Rezoning Transportation Analysis
Petition Number: Insert Zoning Petition #2021-216
General Location Identifier: 02956107

Revision Log:

Date	Description
01-24-2022	First Review (PDM)
02-24-2022	Second Review (PDM)

OVERALL SITE
PLAN

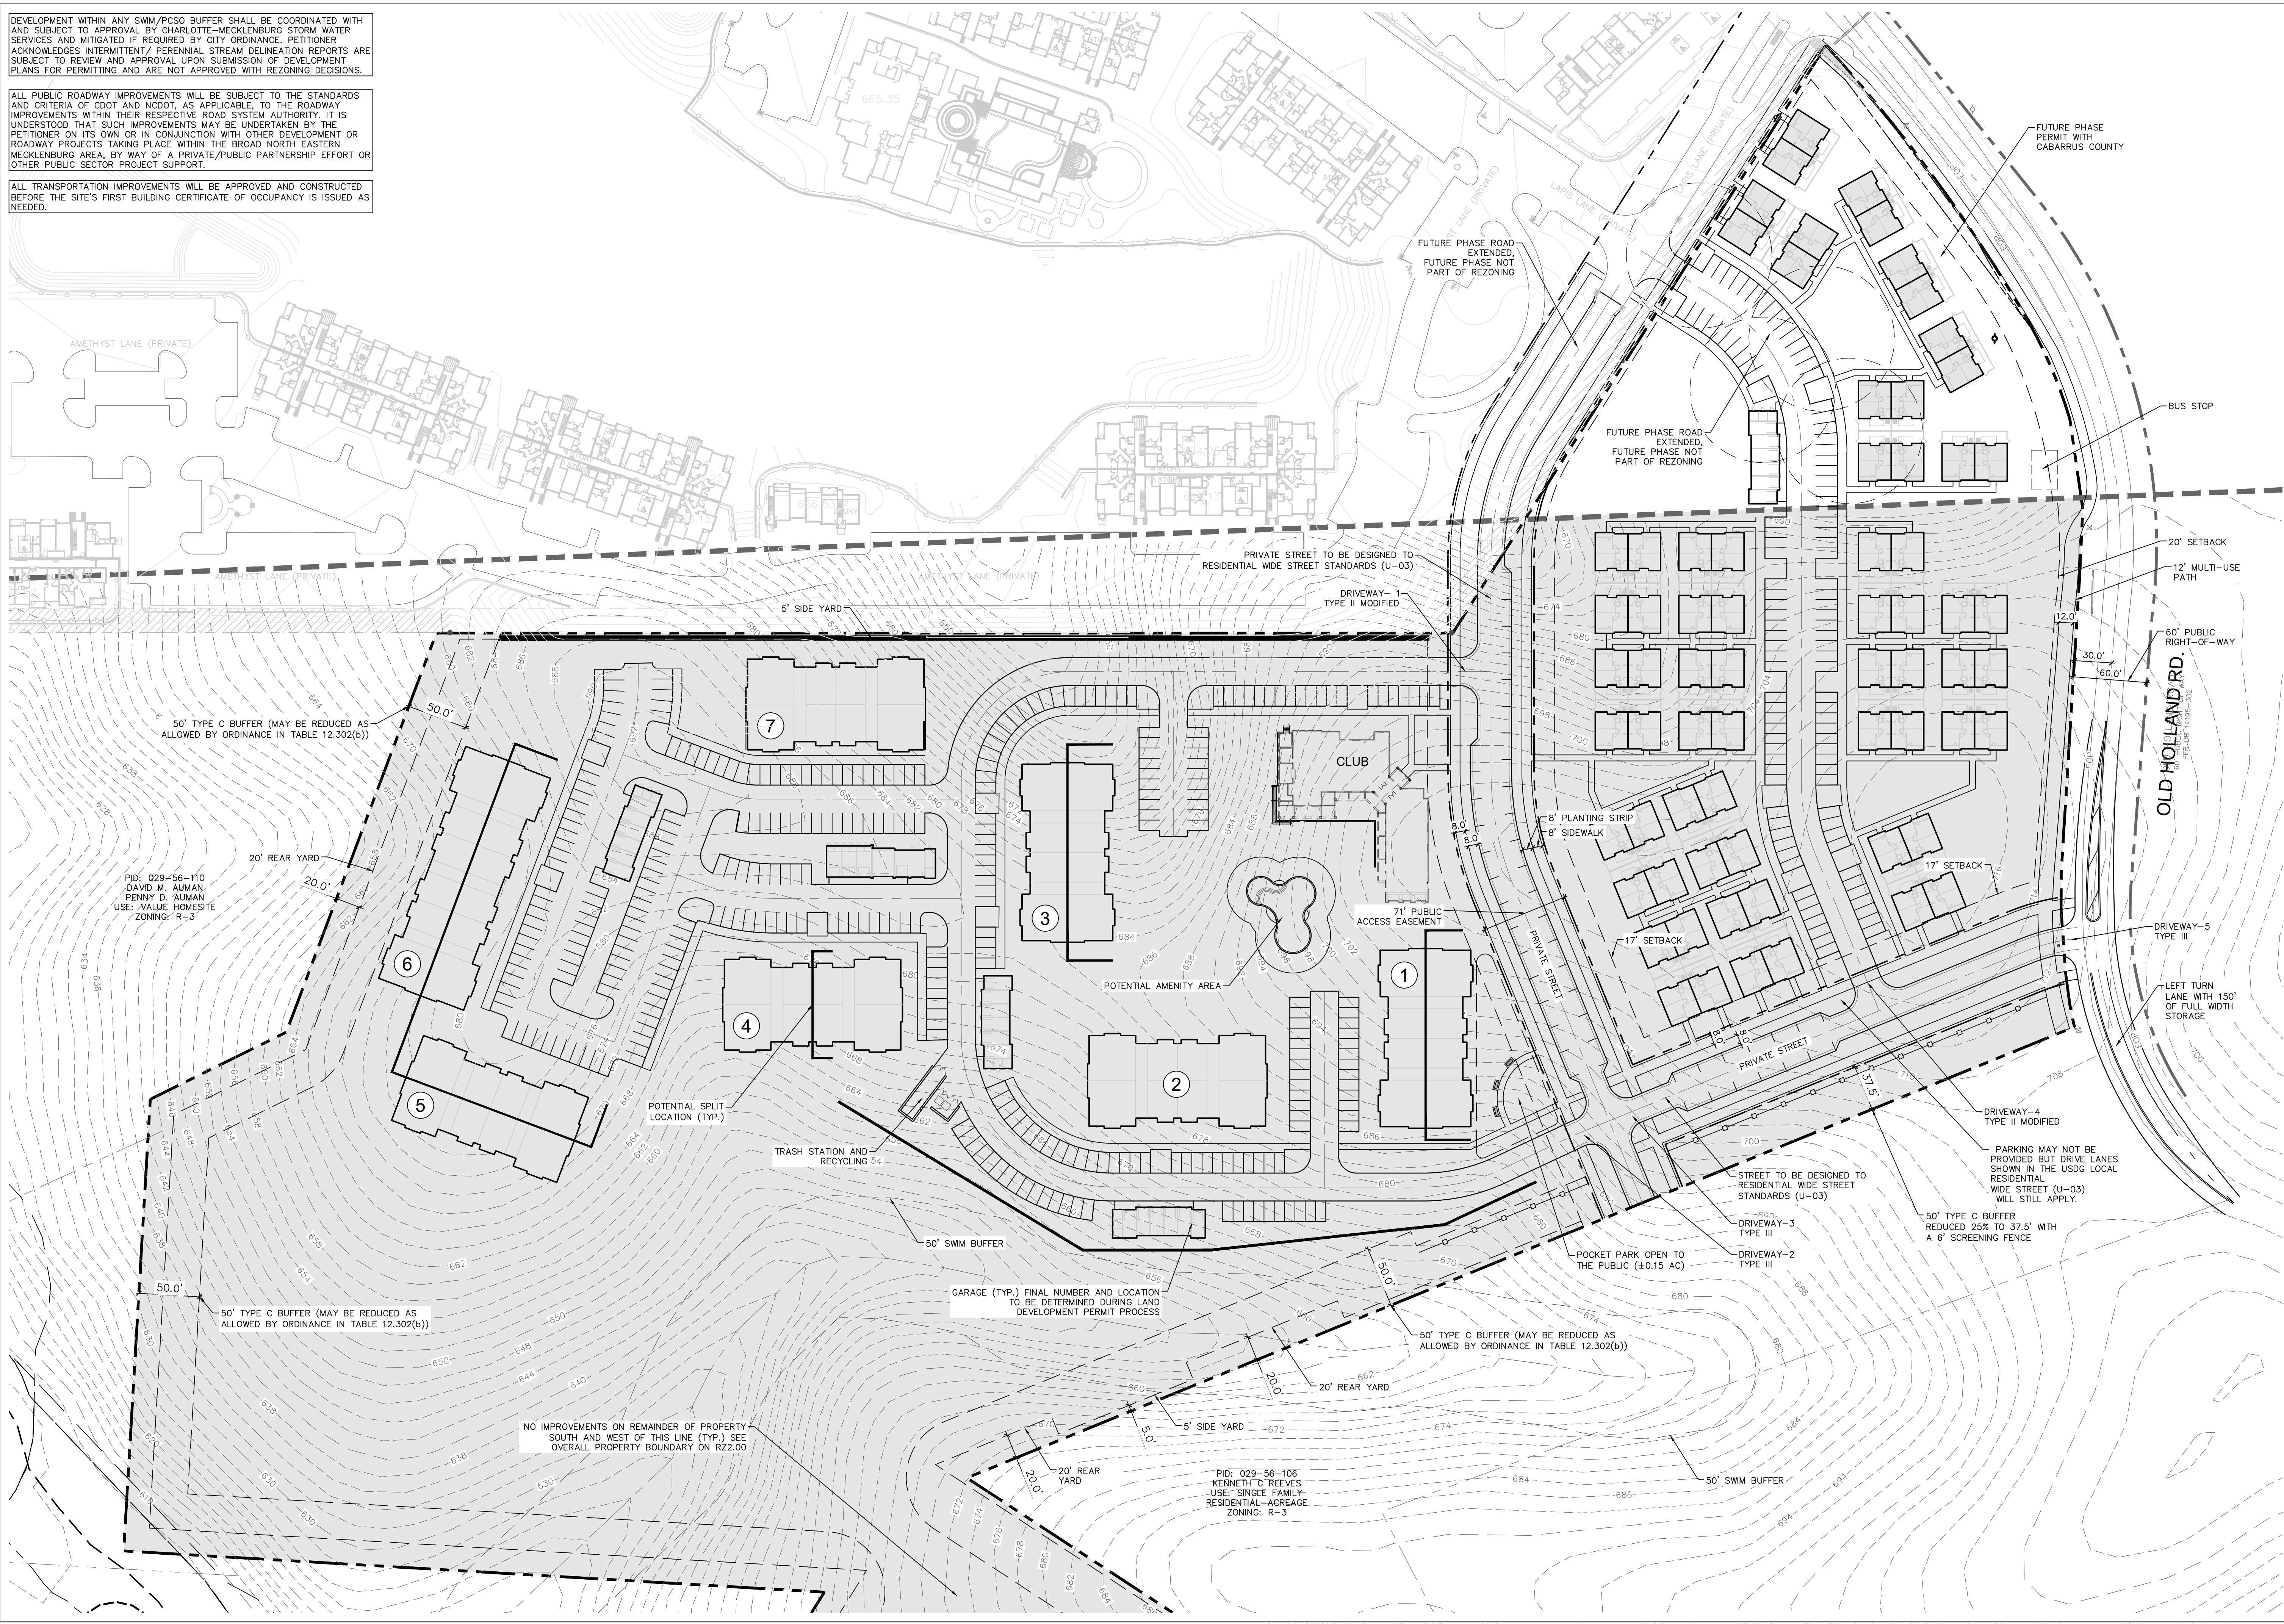
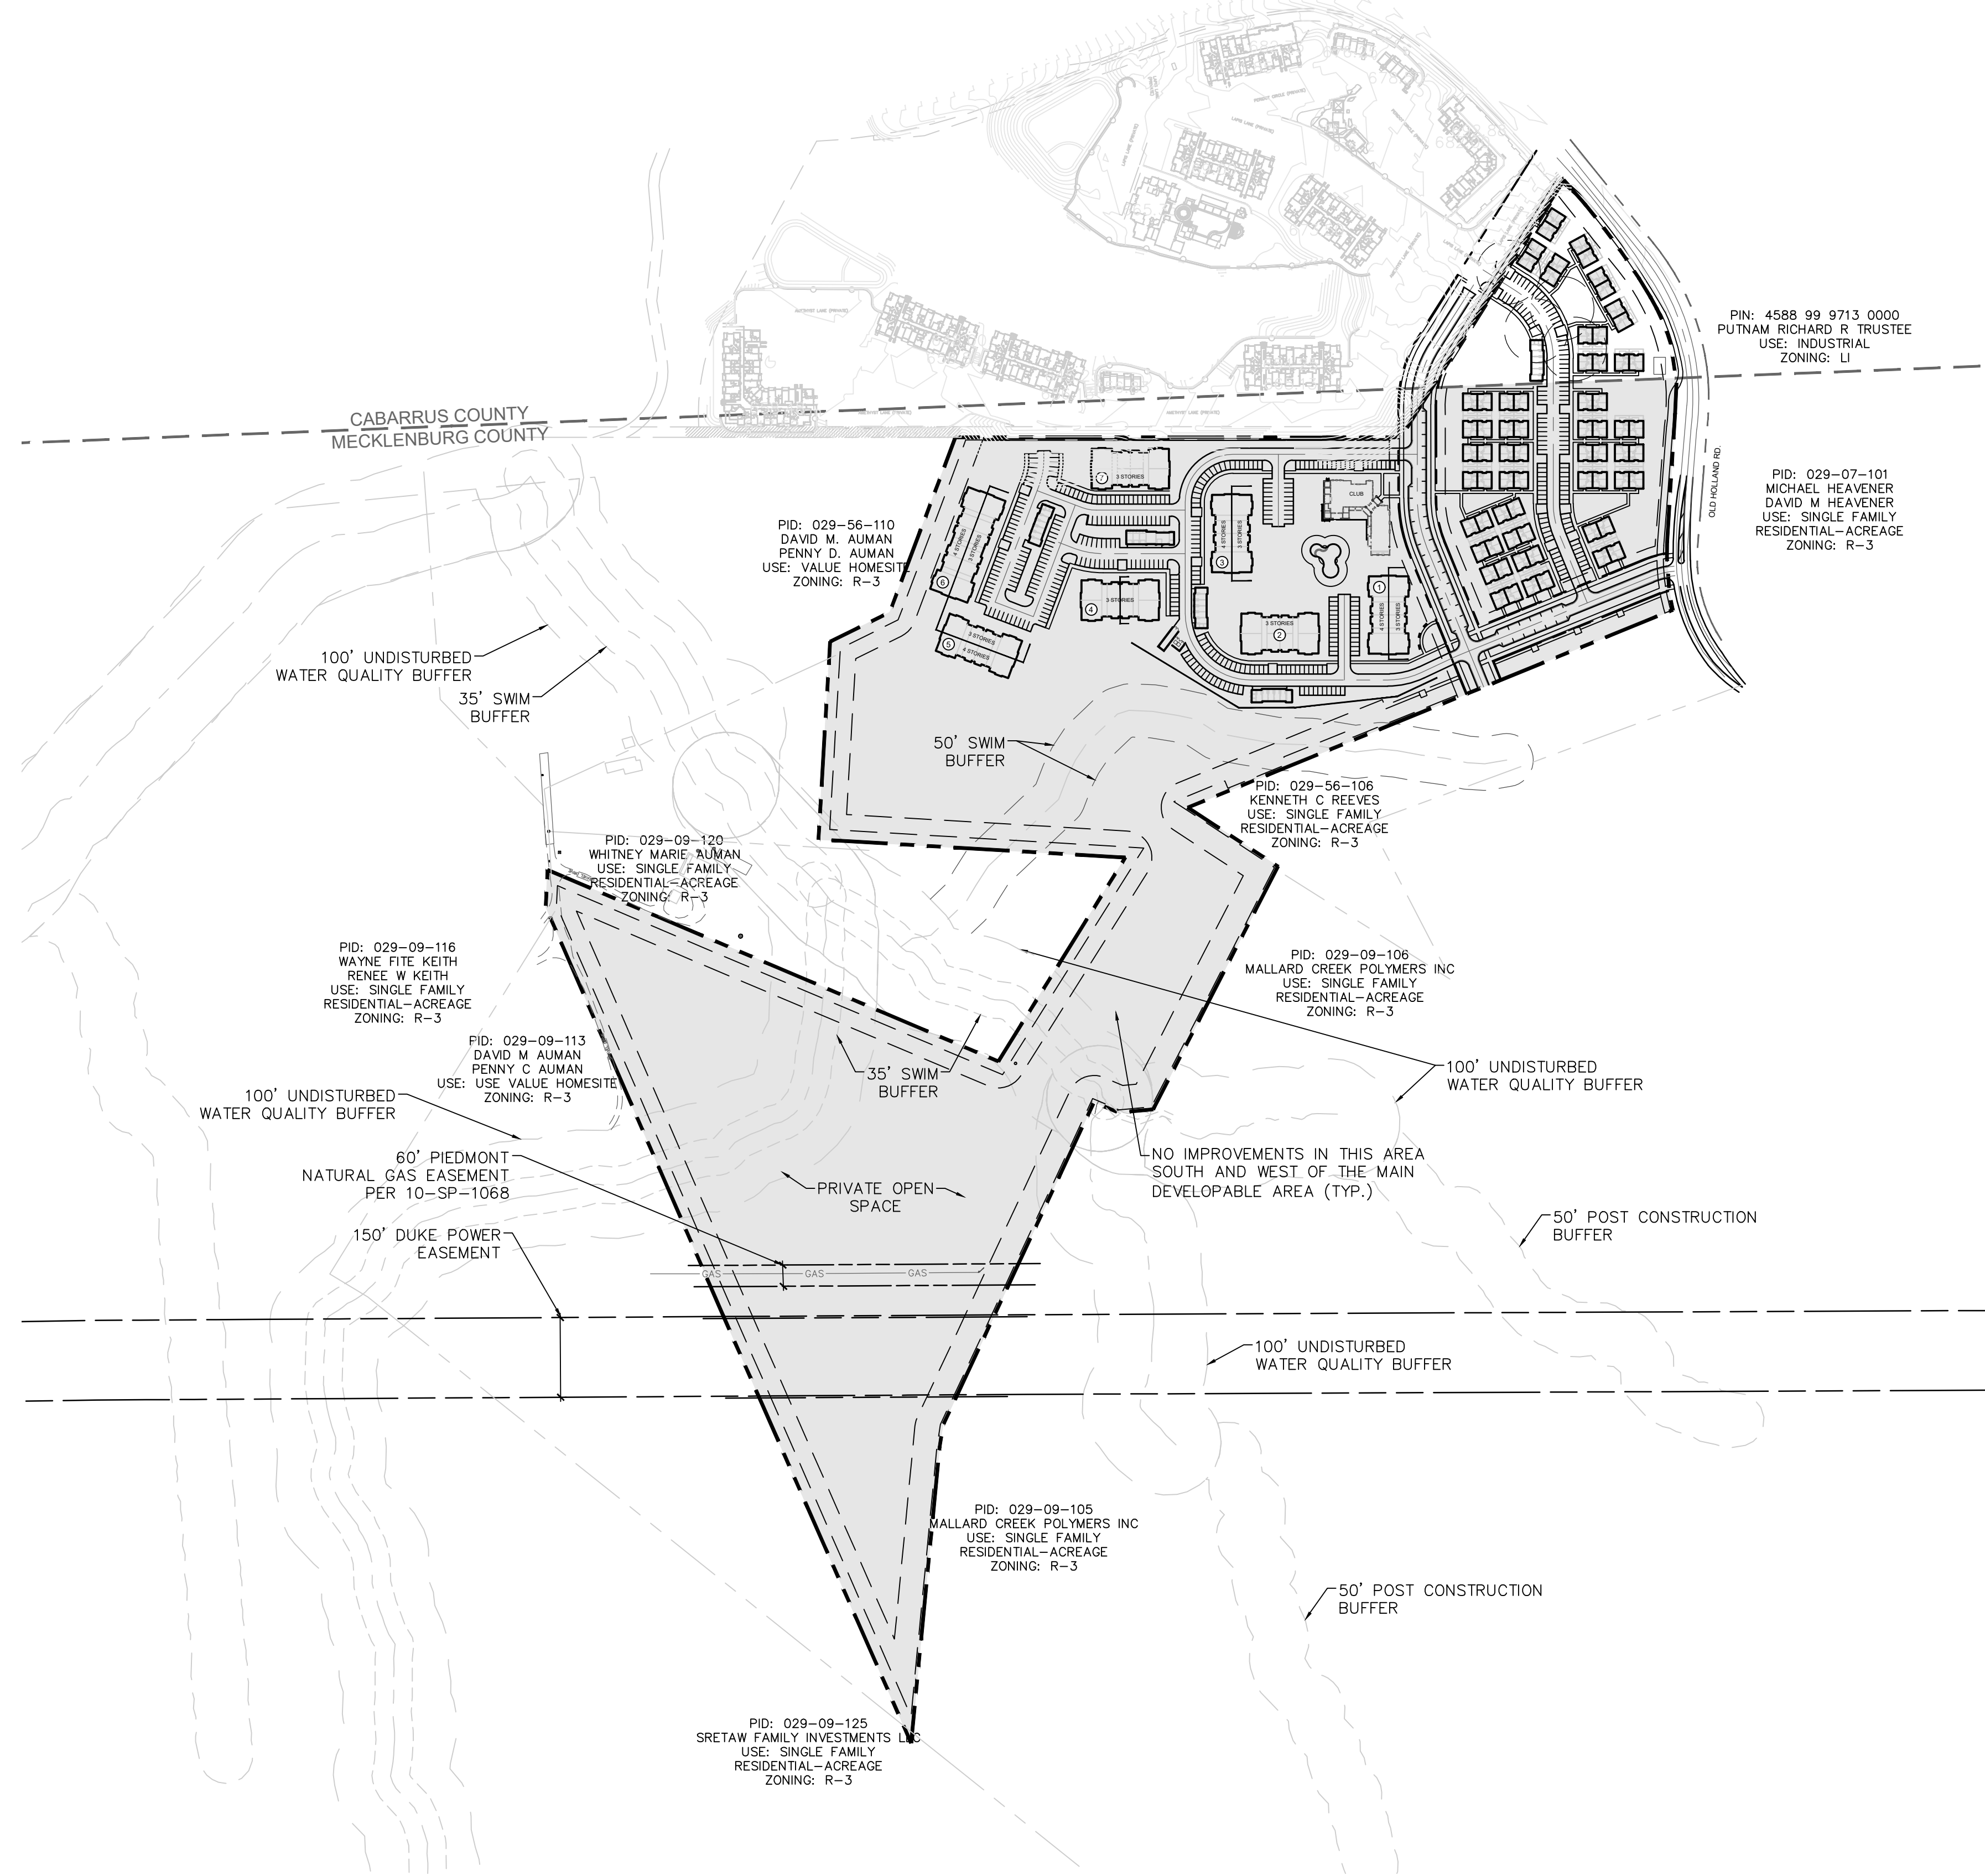
8. **Outstanding Comment from 02.24.2022:** Revise site plan to provide accessible on street parking space(s) in accordance with CLDMS 50.09D and 50.10A

11. Revise site plan to provide ADA ramps to cross the internal street at the intersection of Old Holland Road. The street connection should be designed as an intersection and not a Type III driveway.

12. Revise site plan to provide ADA ramps to cross the internal streets at all internal intersections and driveways.

13. Provide clarification to what is planned for the undeveloped portion of the parcel to the south side of the development. Consider subdividing the parcel to remove this portion from the development. Additional right-of-way may be requested for a future public street in this area based upon the provided clarification.

Clarifying comment from 02.24.22: Remove "under this section C of the development standards for note C.7. because all the required transportation improvements are not listed under section C such as the 12-foot multi-use path on Old Holland.
